City of Portland, Maine - Building or Use Permit Application

Permit No: 04-0456	PERMIT ISSUED Issue Date: MAY 19 2004	BL: 392 A007001
-----------------------	---	--------------------

Location of Construction: 140 Hope Ave (Lot #7)		Owner Name: Shaw Larry R &	Owner Address: 23 Longwoods Rd CITY OF PORTLAND	Phone: 207-780-6156
Business Name: n/a		Contractor Name: Longwood Assoc.	Contractor Address: Portland	Phone: 2077806156
Lessee/Buyer's Name n/a		Phone: n/a	Permit Type: Single Family	Zone: R2
Past Use: Vacant	Proposed Use: Build New 28' x 38' Single Family with 28' x 28' garage.		Permit Fee: \$1,806.00	Cost of Work: \$190,000.00
Proposed Project Description: Build New 28' x 38' Single Family with 28' x 28' garage.			CEO District: 5	
		FIRE DEPT: N/A Signature: [Signature]	INSPECTION: Use Group R-3 Type SB BOCA 1999 Signature: [Signature]	
Action: <input type="checkbox"/> Approved <input type="checkbox"/> Approved w/Conditions <input checked="" type="checkbox"/> Denied				
Signature:			Date:

Proposed Use: Build New 28' x 38' Single Family with 28' x 28' garage and breezeway.	Proposed Project Description: Build New 28' x 38' Single Family with 28' x 28' garage and breezeway.
--	-

FLOOR PLANS

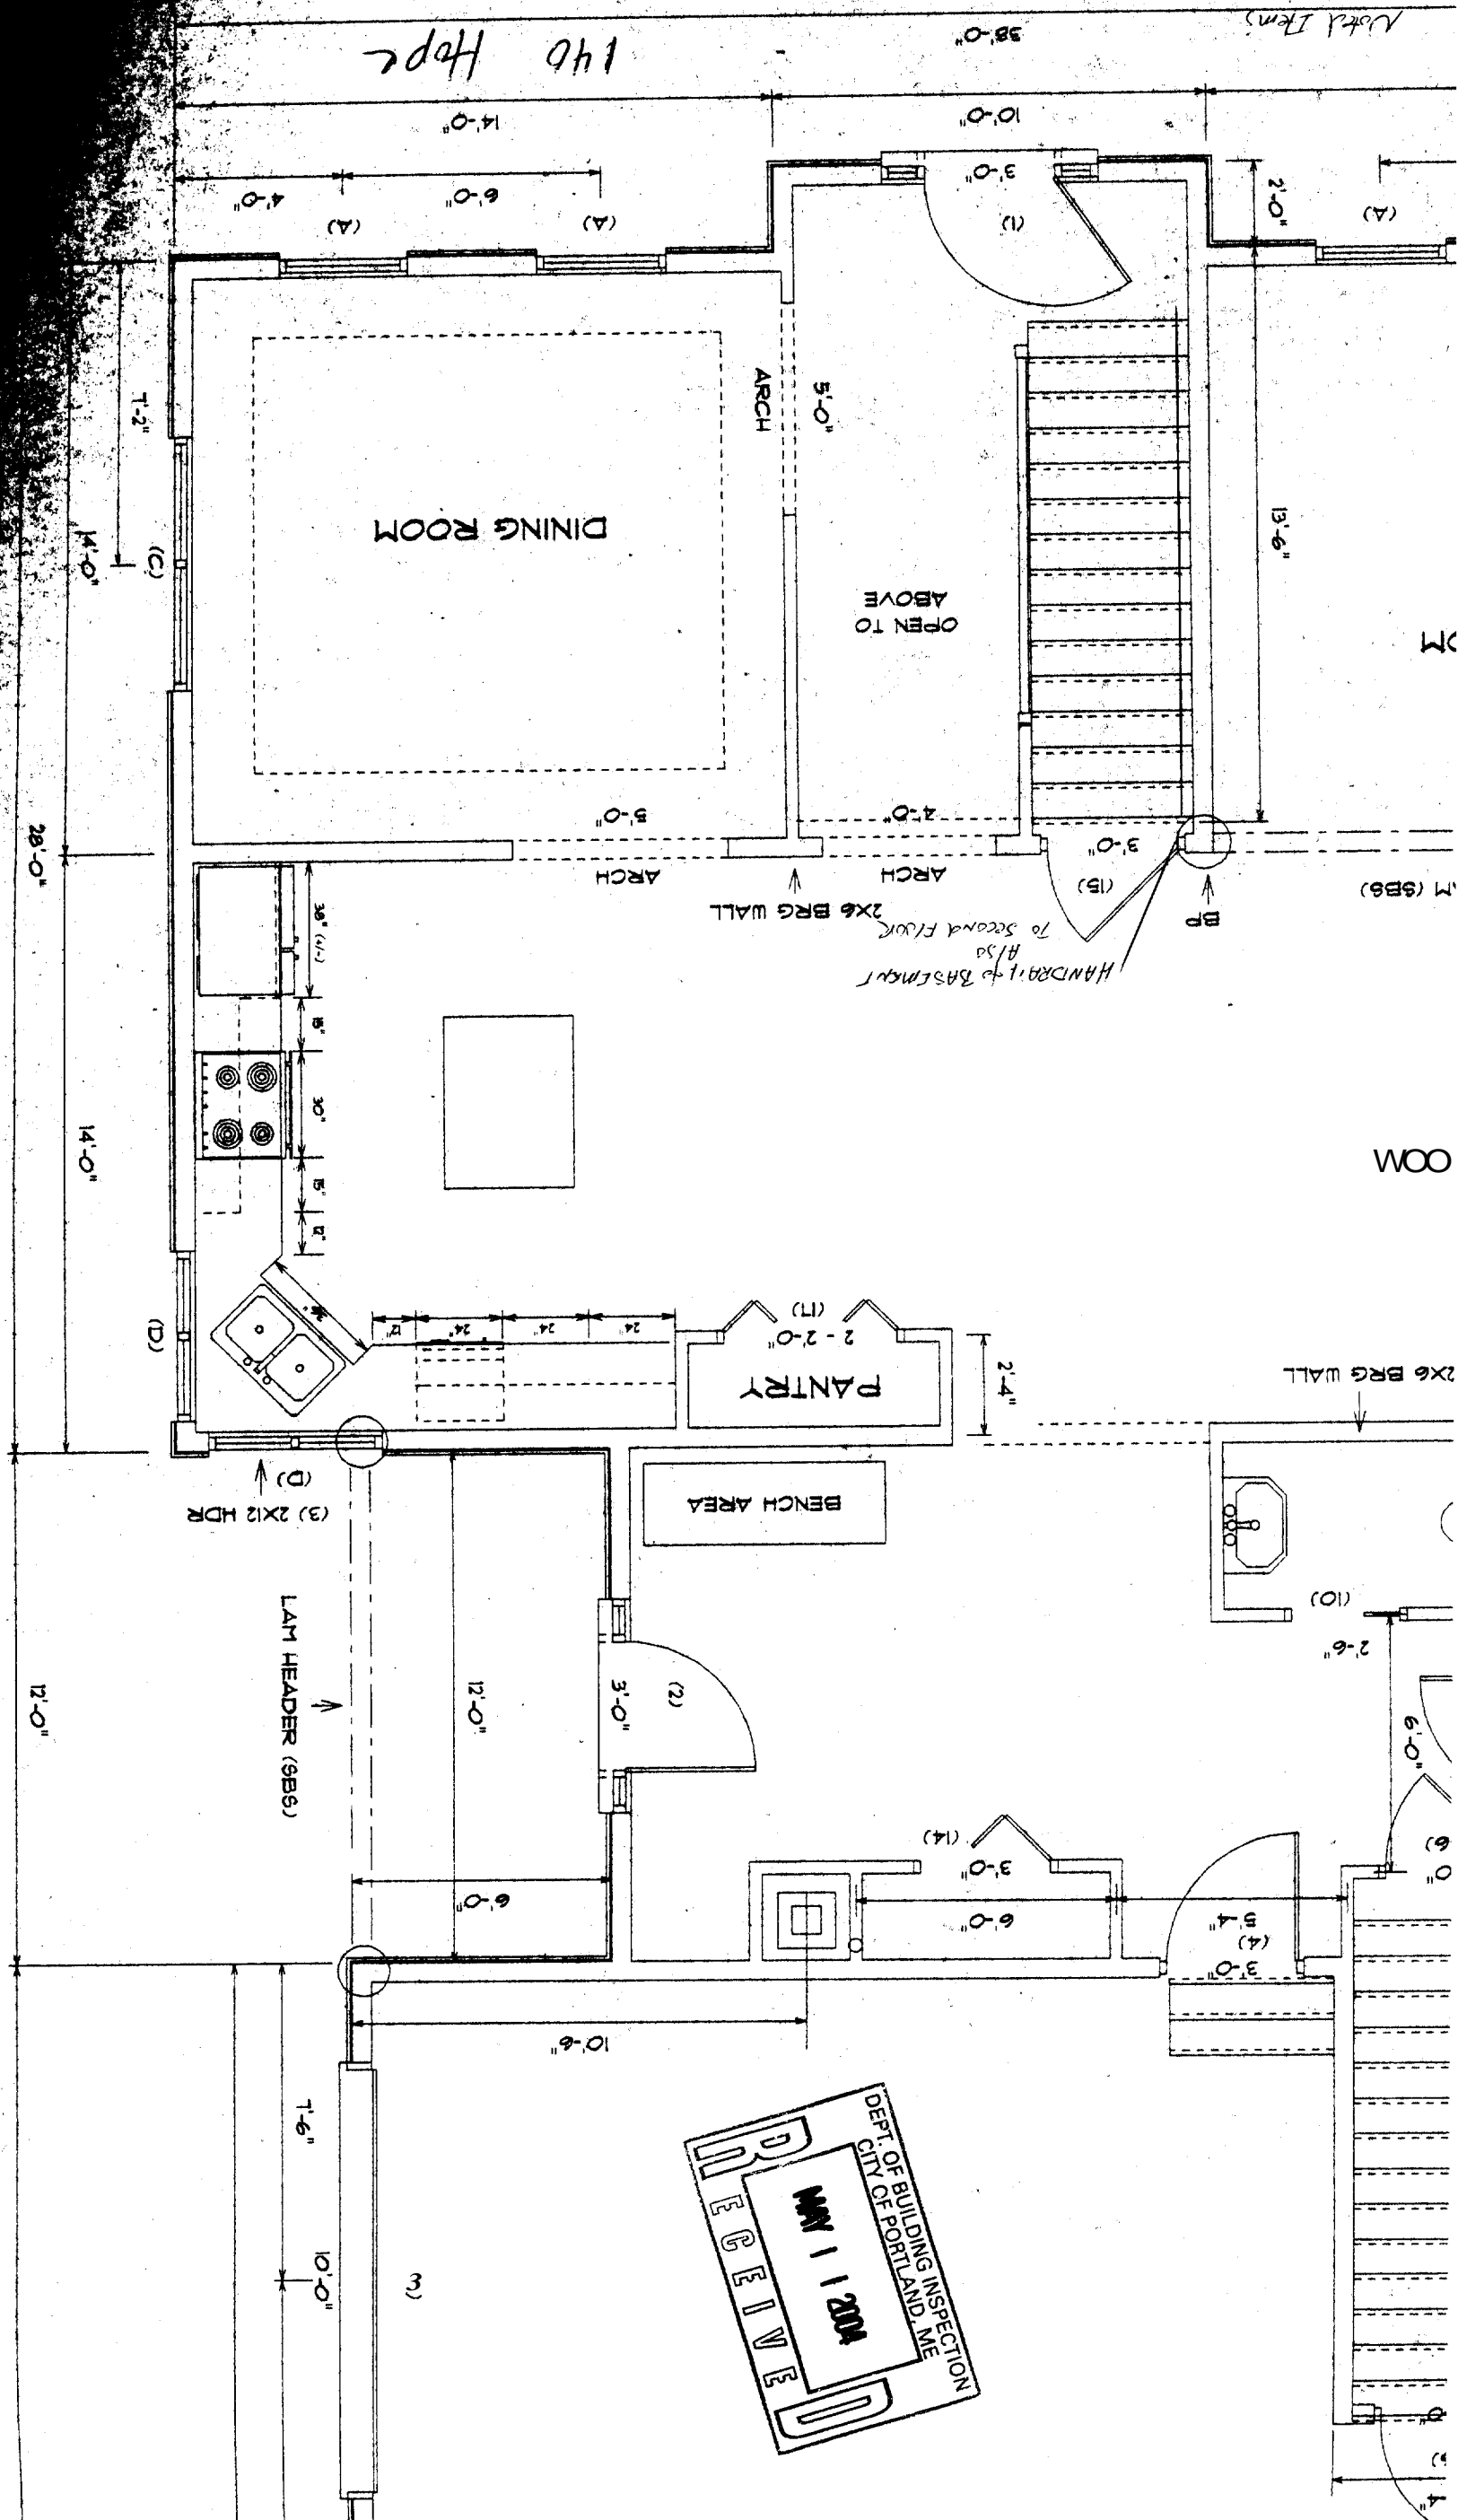
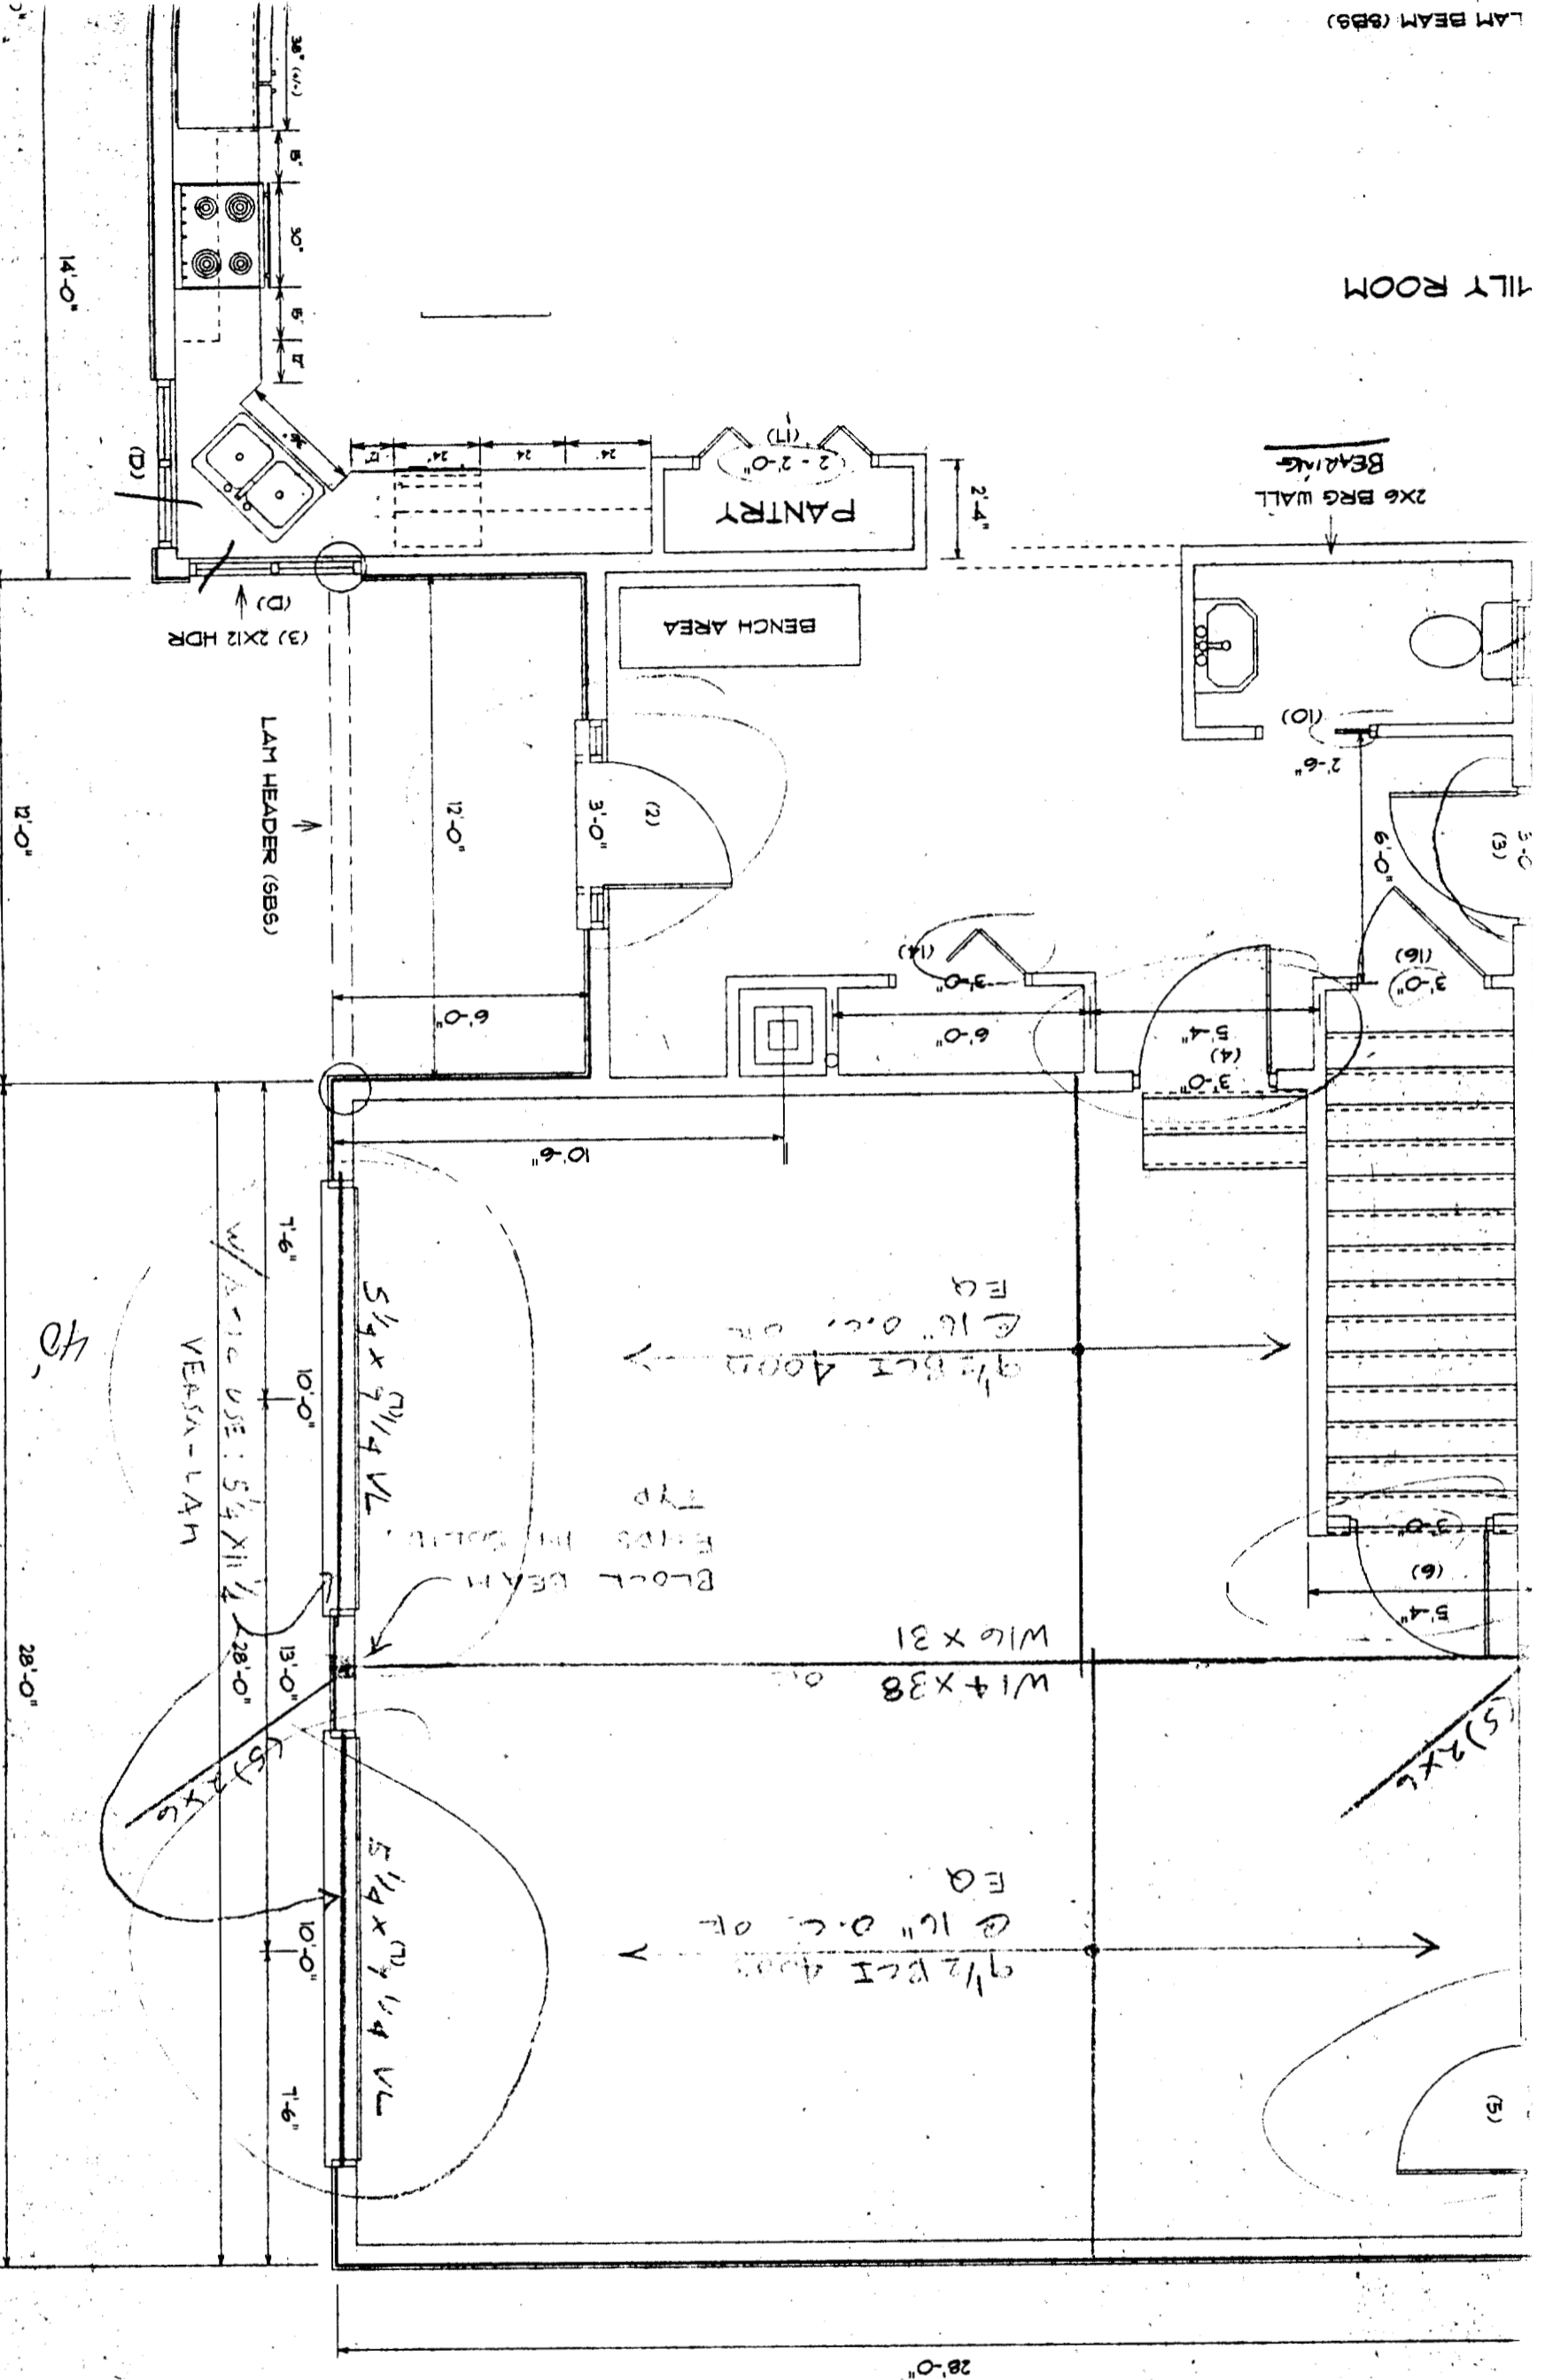
<p>Attic or additional Floor Joist Species Dimensions and Spacing (Table 802.4.2 or 503.3.1(1) & Table 503.3.2(1))</p>	<p>Truss</p>	
<p>Roof Rafter; Pitch, Span, Spacing & Dimension (Table 802.3.2(7))</p>	<p>Tresses } Need specs</p>	
<p>Sheathing; Floor, Wall and roof (Table 503.2.1(1))</p>	<p>OK</p>	
<p>Fastener Schedule (Table 602.3(1) & (2))</p>	<p>Not shown</p>	
<p>Private Garage Section 309 and Section 407 1999 BOCA) Living Space ? Yes</p>	<p>Not shown where</p>	
<p>Fire separation</p>	<p>OK shows 1 hour</p>	
<p>Fire rating of doors to living space Door Sill elevation (407.5 BOCA)</p>	<p>Not noted as egress</p>	
<p>Egress Windows (Section 310)</p>	<p>OK</p>	
<p>Roof Covering (Chapter 9)</p>	<p>OK</p>	
<p>Safety Glazing (Section 308)</p>	<p>OK</p>	
<p>Attic Access (BOCA 1211.1)</p>	<p>Shows 21"x36" - Min is 22"x30"</p>	
<p>Draft Stopping around chimney</p>	<p>Clearances + draft stopping -</p>	<p>Not shown</p>

Header Schedule	Not shown	
Type of Heating System	OK	
Stairs		
Number of Stairways		
Interior 2		
Exterior 2		
Treads and Risers - OK - not ok - Exterior - Not shown (Section 314)		
Width 3' - OK		
Headroom OK		
Guardrails and Handrails (Section 315)	Not shown	
Smoke Detectors Location and type/Interconnected	Not shown	
Plan Reviewer Signature
